Location: Springwood Drive, Whalley, BB7 9XL – Phase 2, Lawsonsteads.
Proposal: Approval of details reserved by condition 14 (drainage) on planning permission 3/2021/0760.

Condition 14

APPLICATION NO. 3/2026/0312

Drawing Title: **S104 LAYOUT**

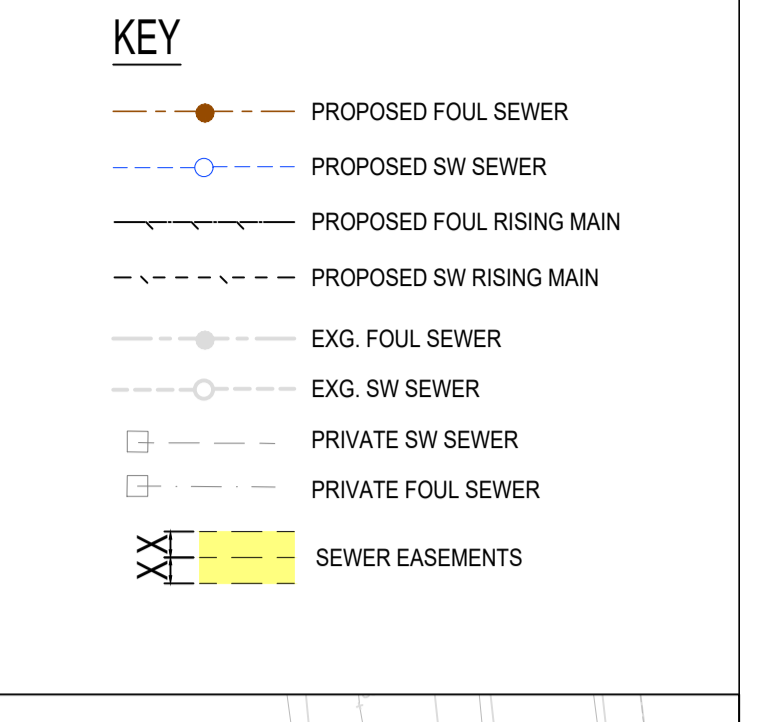
Condition 14 (drainage) cannot be discharged at this stage insofar that further information is required in order to satisfy the condition, which has not yet been forthcoming. This includes evidence that the proposed drainage system will not exceed a maximum rate of 57.7 l/s; a site layout plan showing flood water exceedance routes, both on and off site; drainage calculations that demonstrate the proposed drainage system that include design storm period and intensity, appropriate parameters and additional uplifts such as urban creep and climate change; and temporary surface water storage facilities.
